Single storey sun room extension to the side of the property and the lengthening of the porch 'lean to' roof with new bow window below .

Holly Cottage 27A Belle Meade Close Aldingbourne

Thank you for your internet representation made on 15th November 2018 which has been recorded as '**an objection**' with the comments as follows:

PROPOSED ELEVATIONS

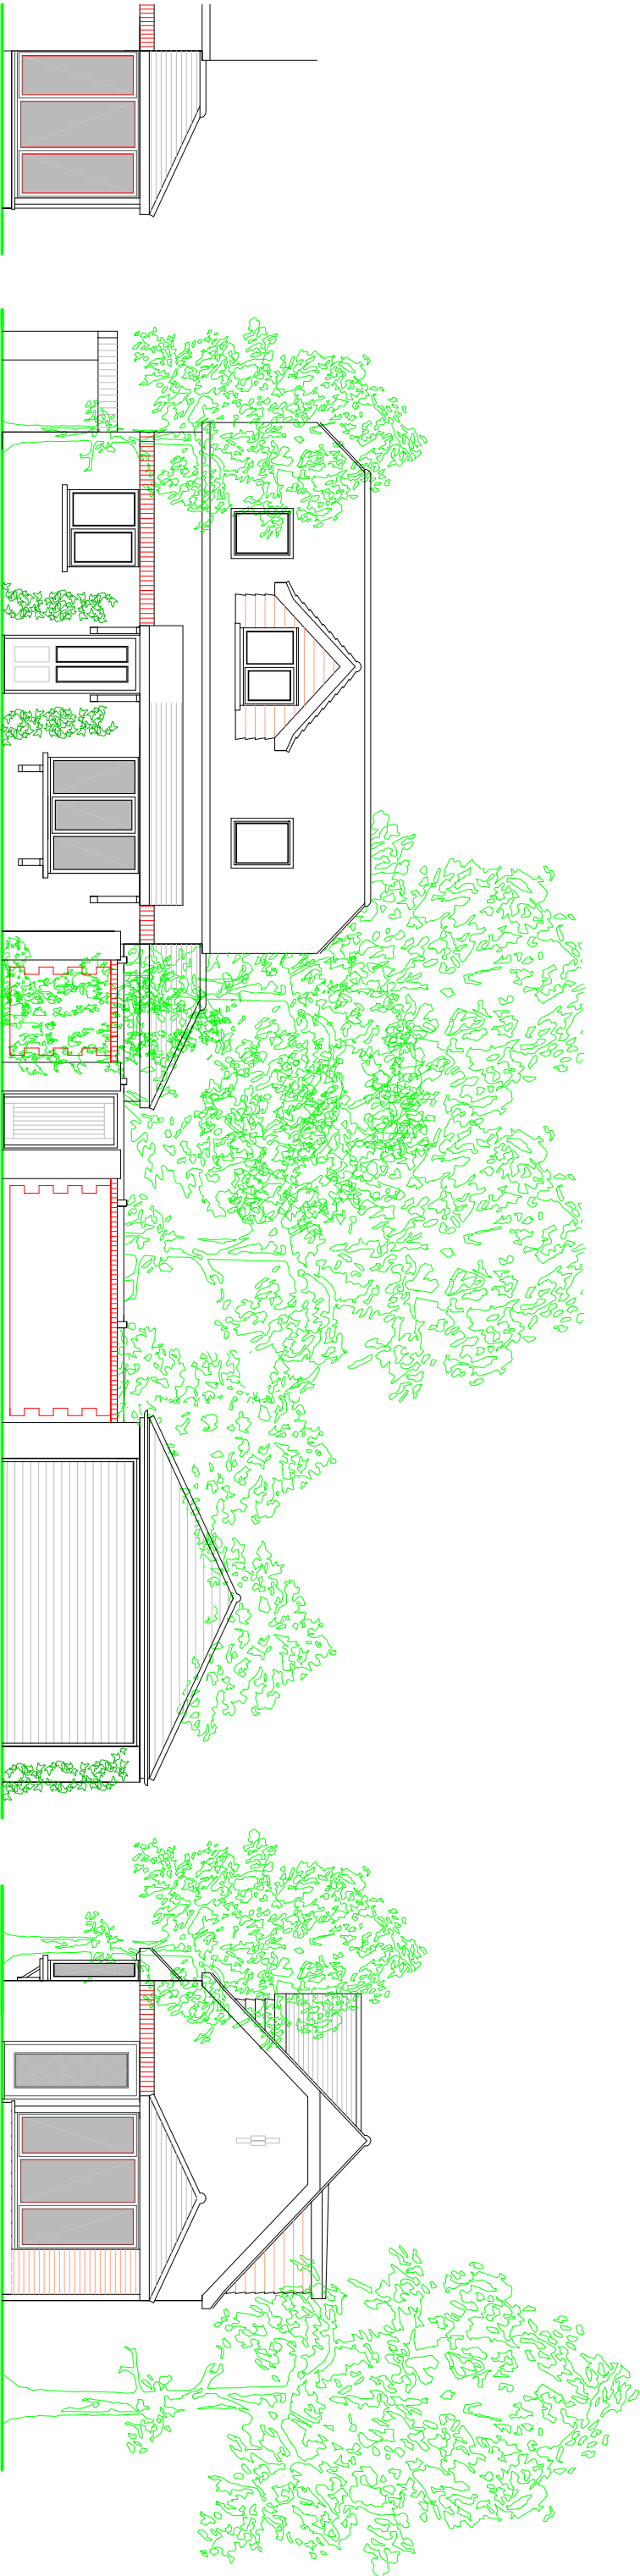
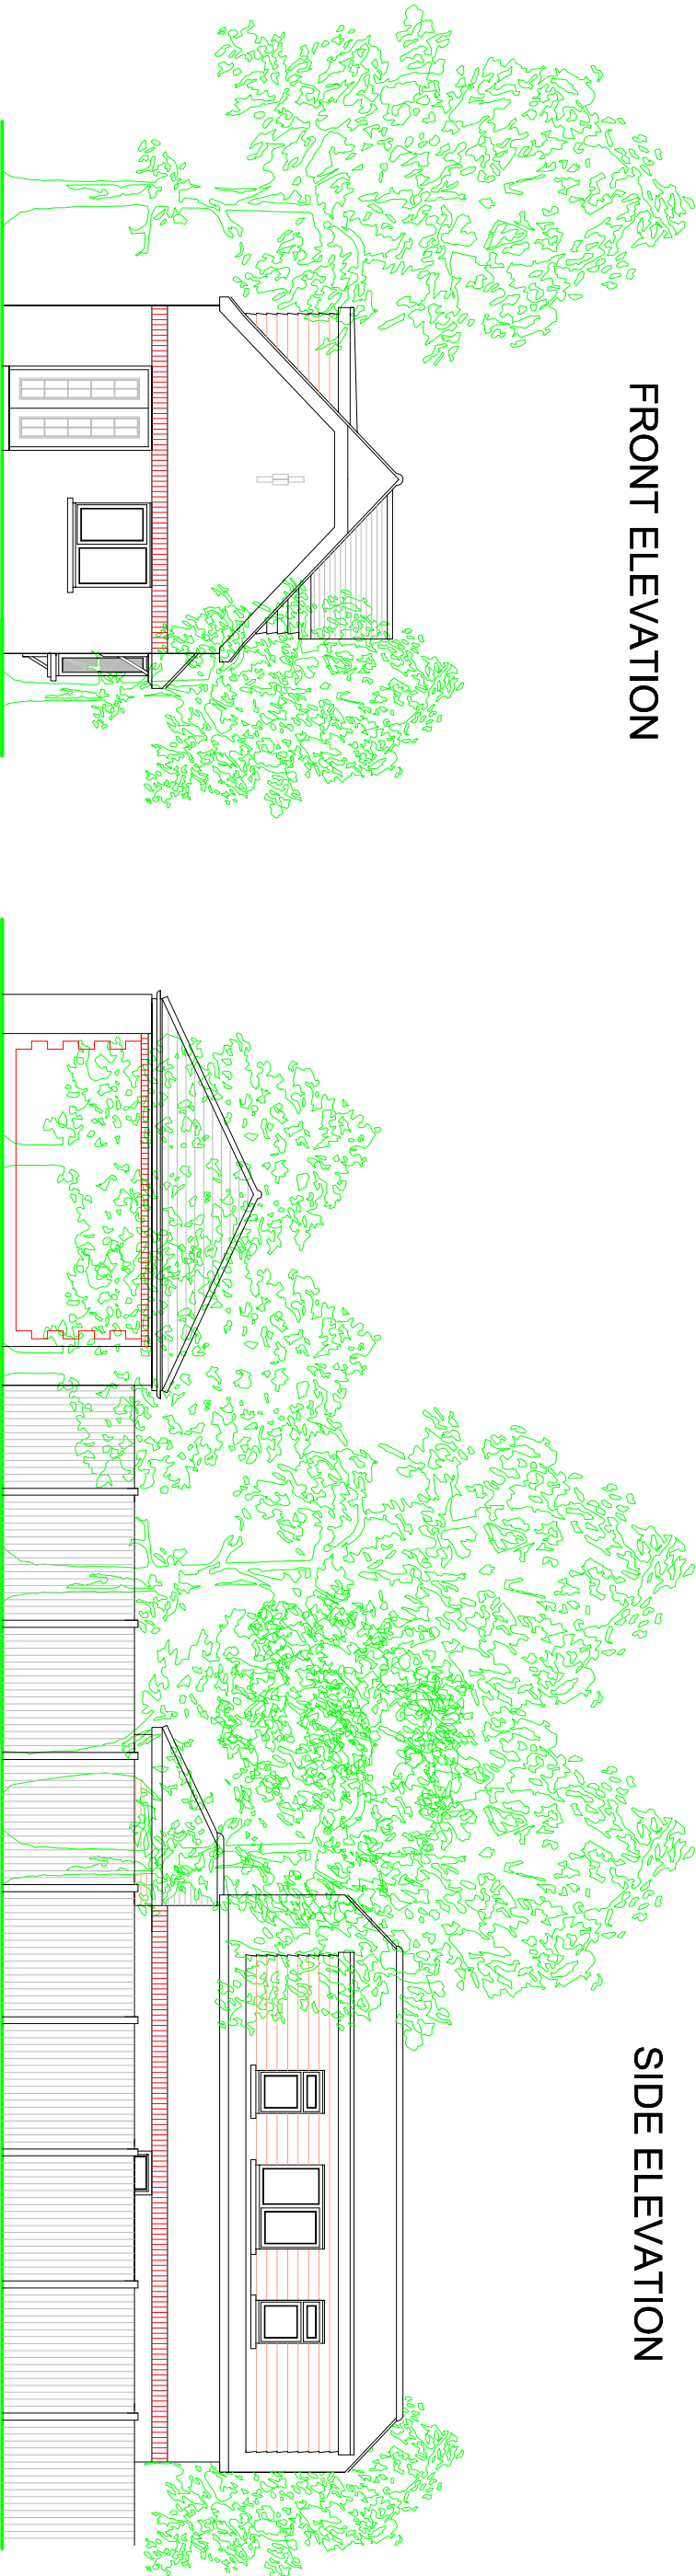
Over-development of a very small plot. I am objecting because this development is cramped enough, also the porch and boxed window is not in-keeping with street aesthetics as no other house has a boxed window with porch above.
